From: Kazys Narbutas Consulting [REDACTED]
Sent: 28 July 2020 12:30
To: Mahmud Choudhury
Cc: Michael Hartnett; Sylvia Rowbotham; Ian Clark; Lauren Dyer; Colin Button
Subject: RE: Langford, Horsemere Green Lane, Climping, BN17 5QZ: Ref CM/64/19/PL - Revised Engineering Details
Attachments: Horsemere Green Lane S106Approval Letter_30-04-2020.pdf; KNC1933-501-02-A Standard Construction Details.pdf; KNC1933-502-01-E Drainage Layout.pdf

Subject: Langford, Horsemere Green Lane, Climping, BN17 5QZ: Ref CM/64/19/PL - Revised Engineering Details

Subject: RE: Langford, Horsemere Green Lane, Climping, BN17 5QZ: Ref CM/64/19/PL (Email 1 of 2)

Engineering Details
Longitudinal Sections

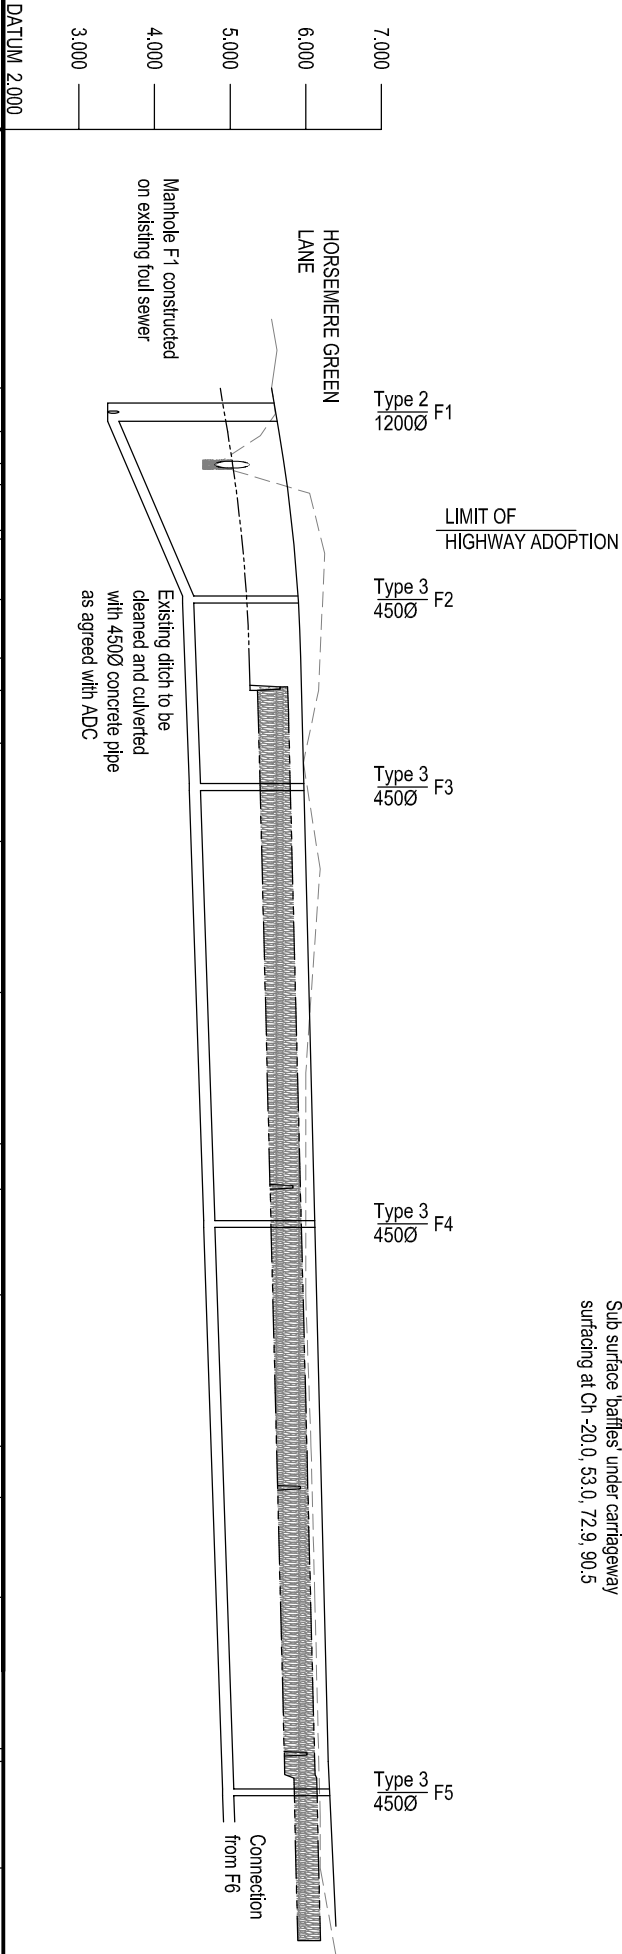
6. Land drainage consent – culvert under access road to be min. 450mm diameter (assuming suitable cover can be achieved). Fully detailed construction drawings required including invert levels, etc. Provide

Section Through Access Road Construction Detail Type 2
Adjacent Drainage Ditch
Scale 1:25

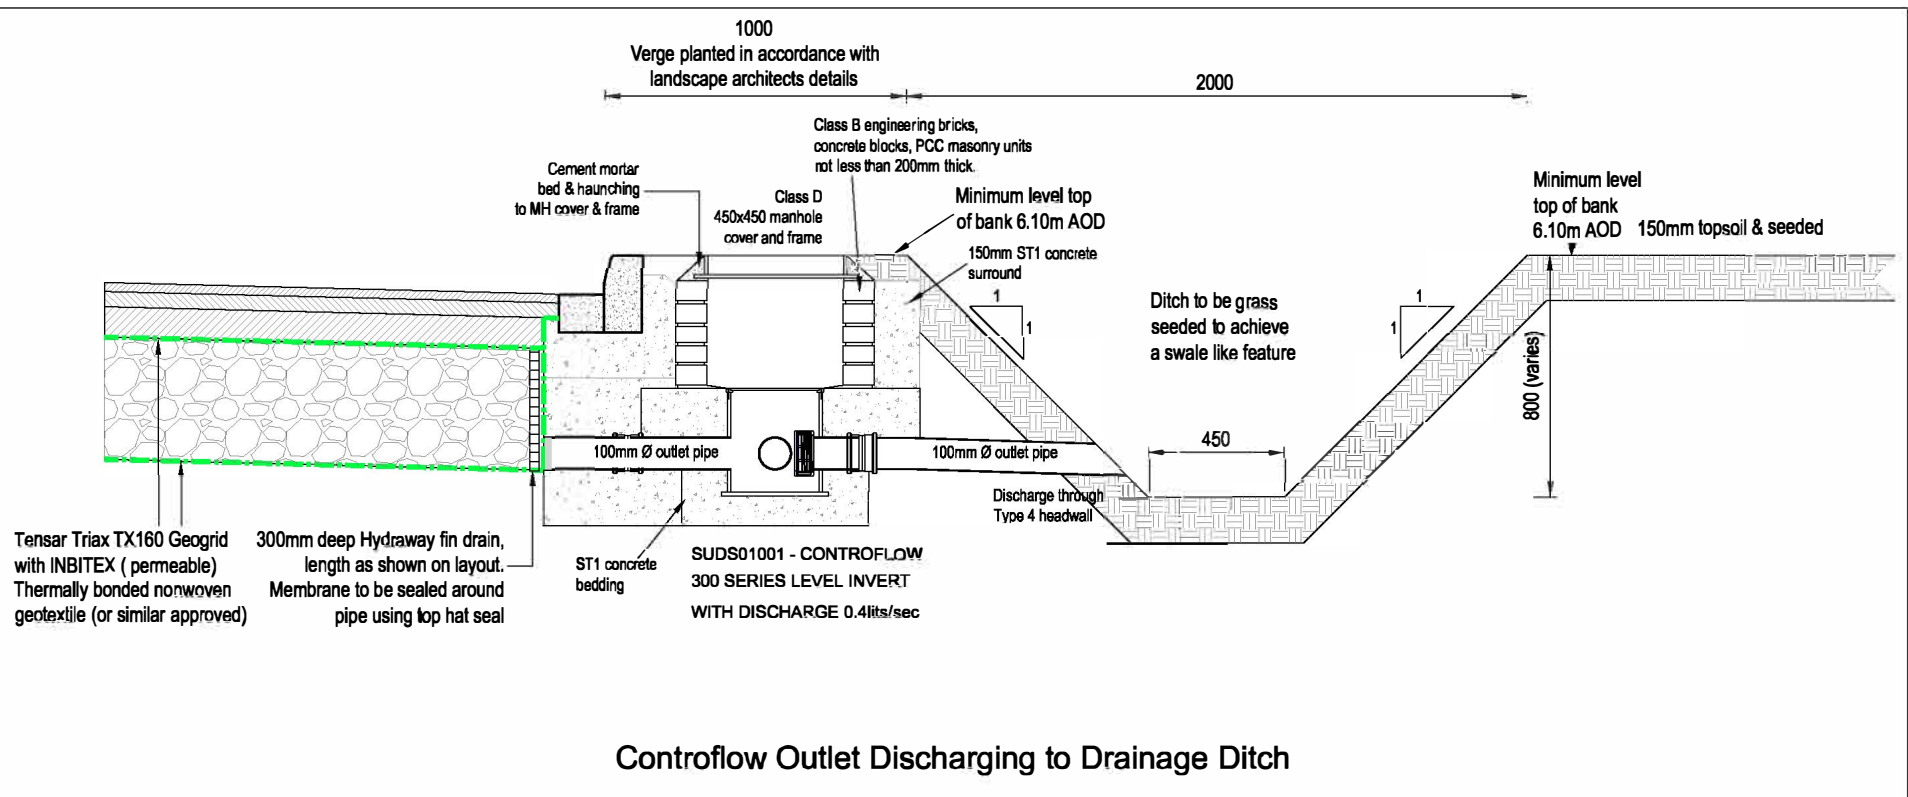
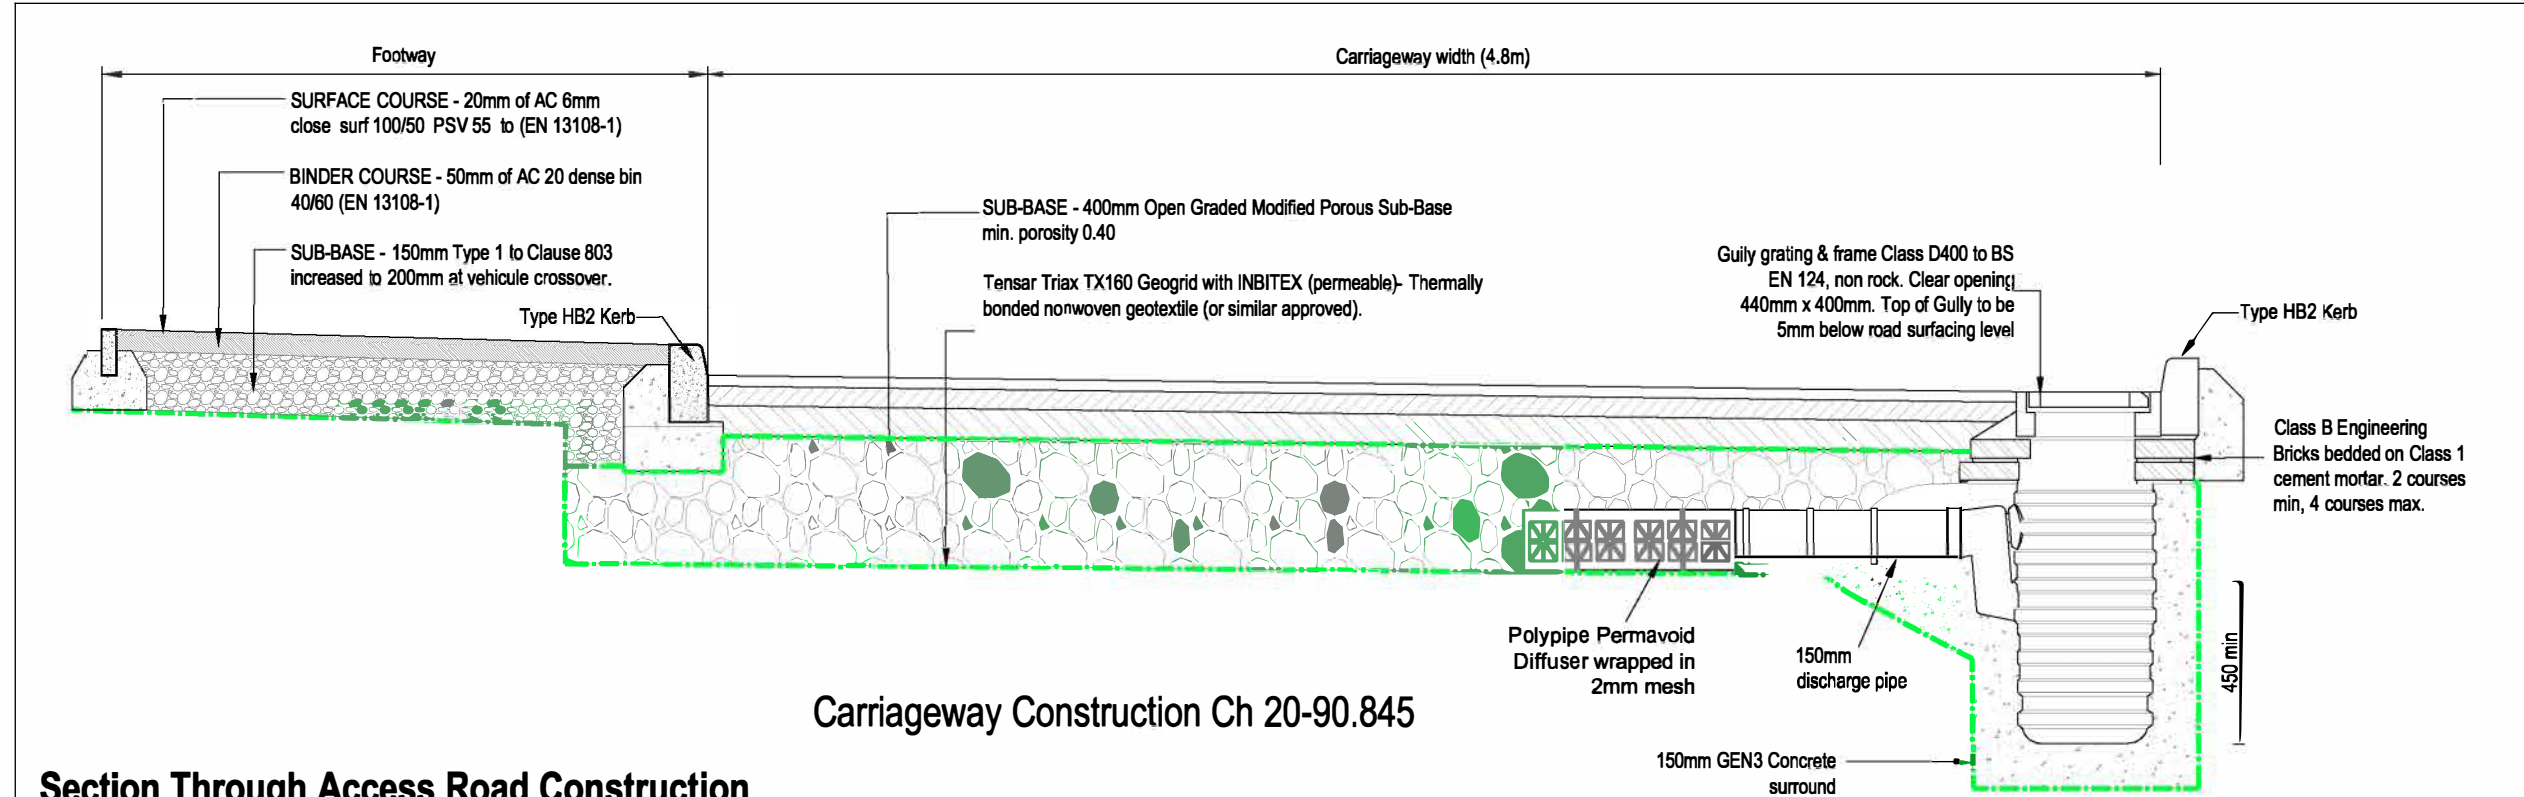
levels/diameters/locations of existing culverts immediately upstream and downstream. Provide fully detailed construction detail and pipe invert levels for the proposed headwall connection to the ditch.

In Situ Percolation Test

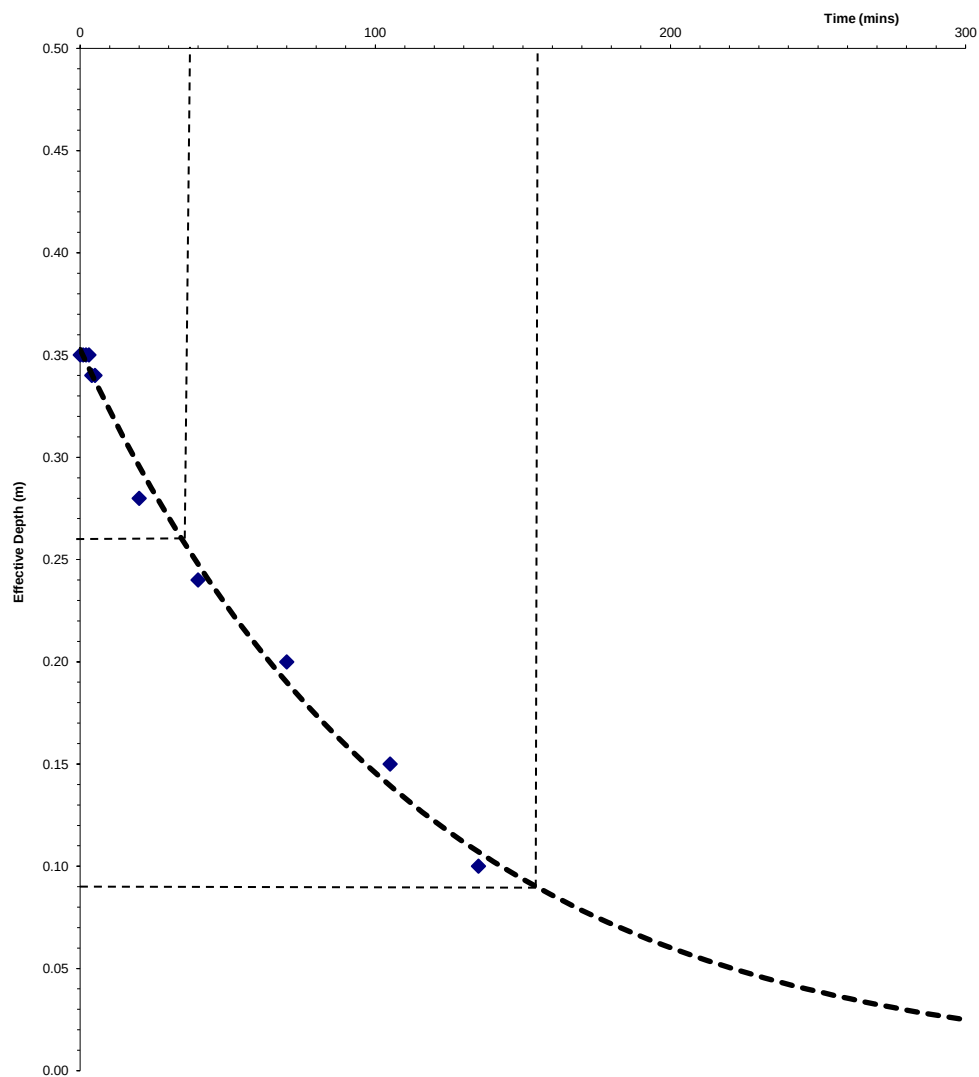
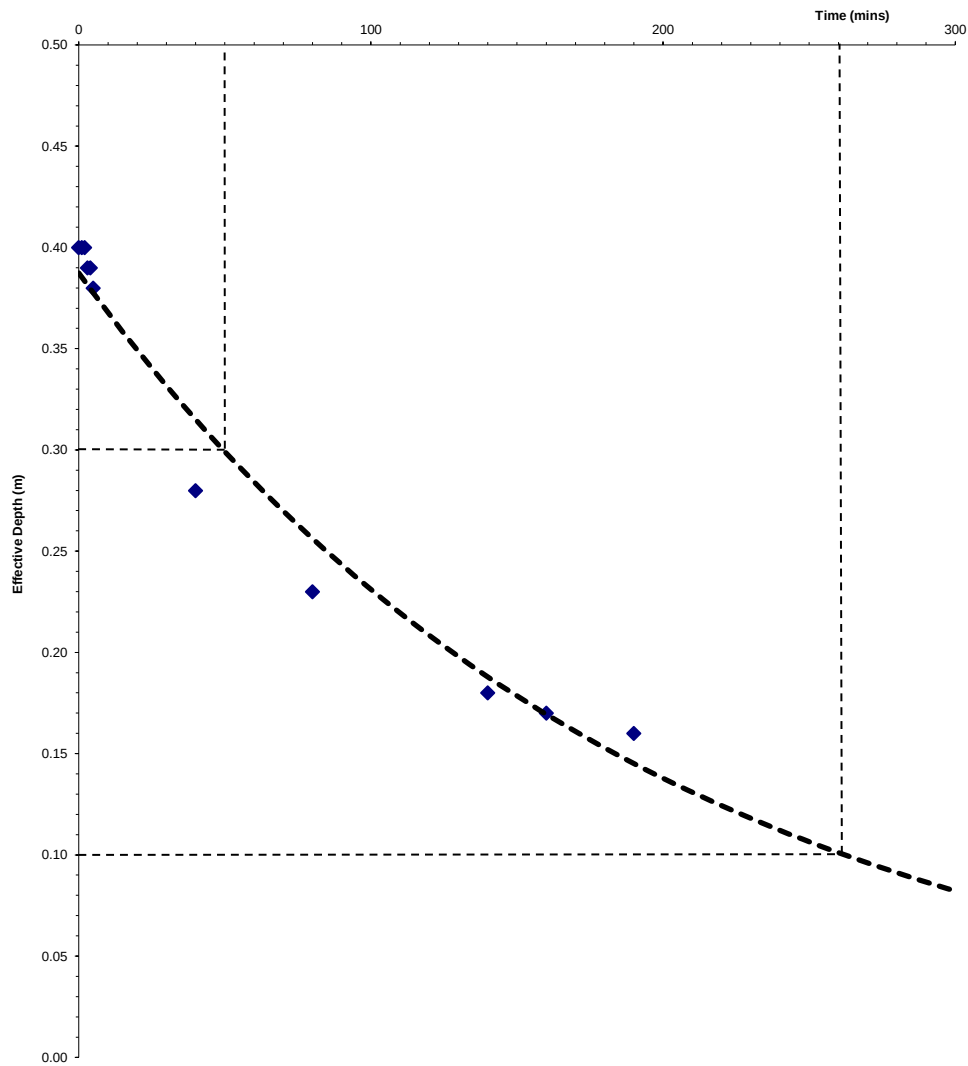
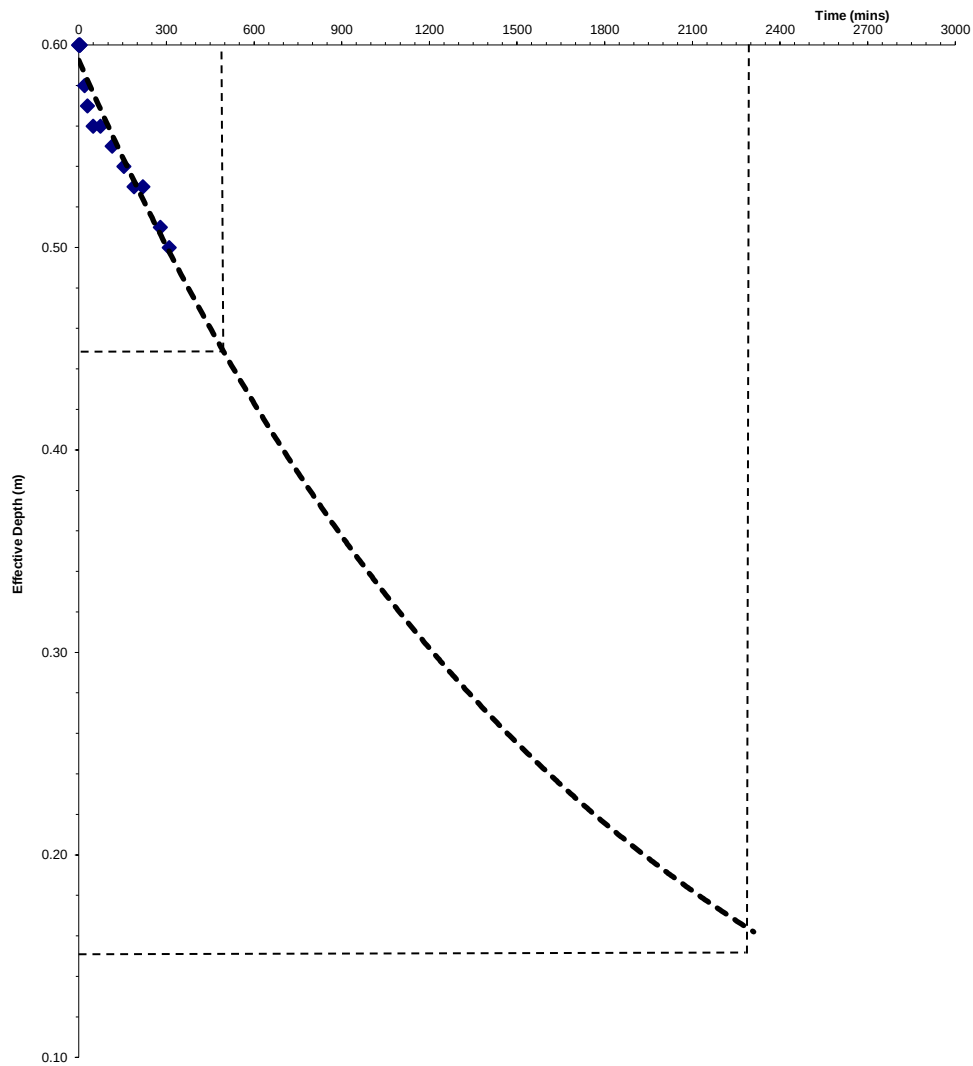
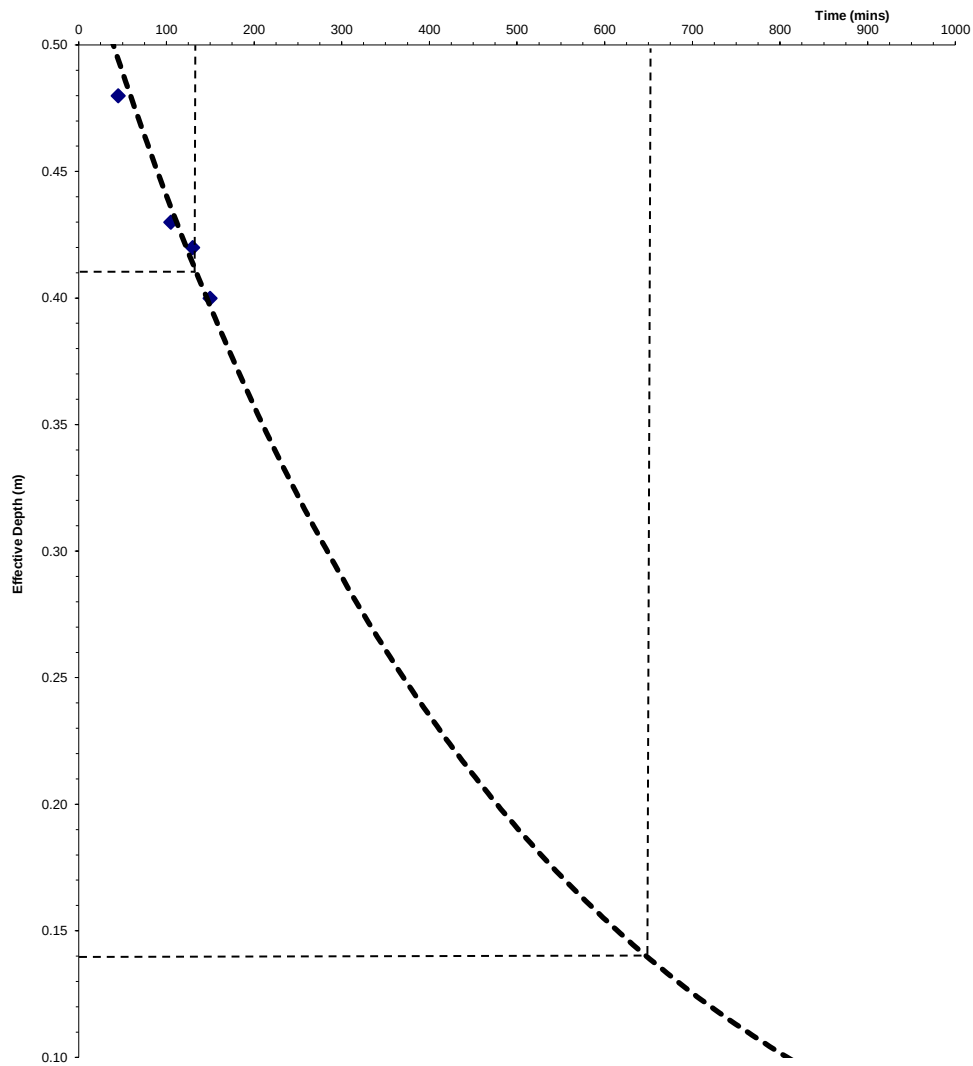
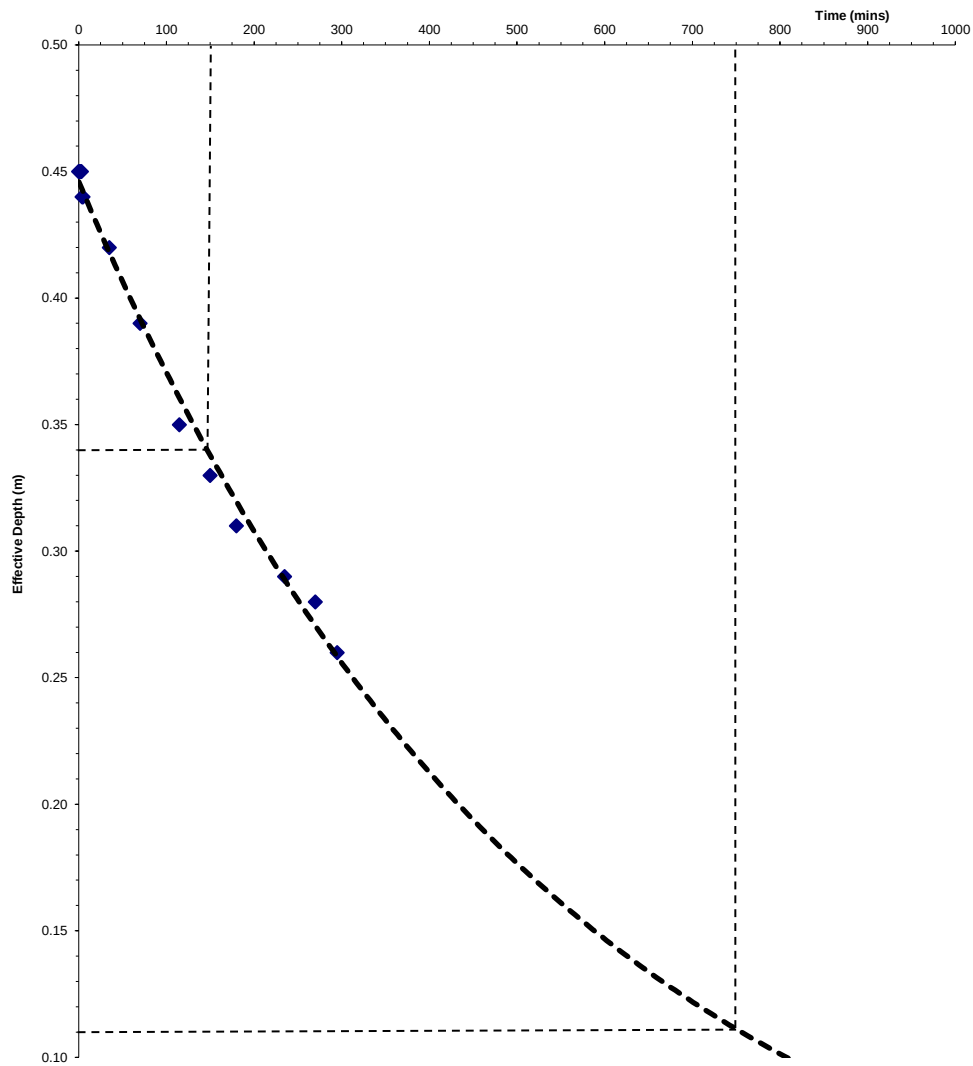
1. 6 months ground water monitoring has not been provided, luckily the monitoring just about captured the peaks we experienced this winter.
2. The infiltration testing did not comply with BRE365 ie. pits were not refilled (ie. 3 tests required in each pit) and the holes were not sufficiently monitored, meaning that final readings had to be estimated. The tests (March 2020) were also carried out too deep ie. should have been carried out at depths based upon the peak Dec 2019 groundwater levels, not the groundwater levels at the time of the tests.
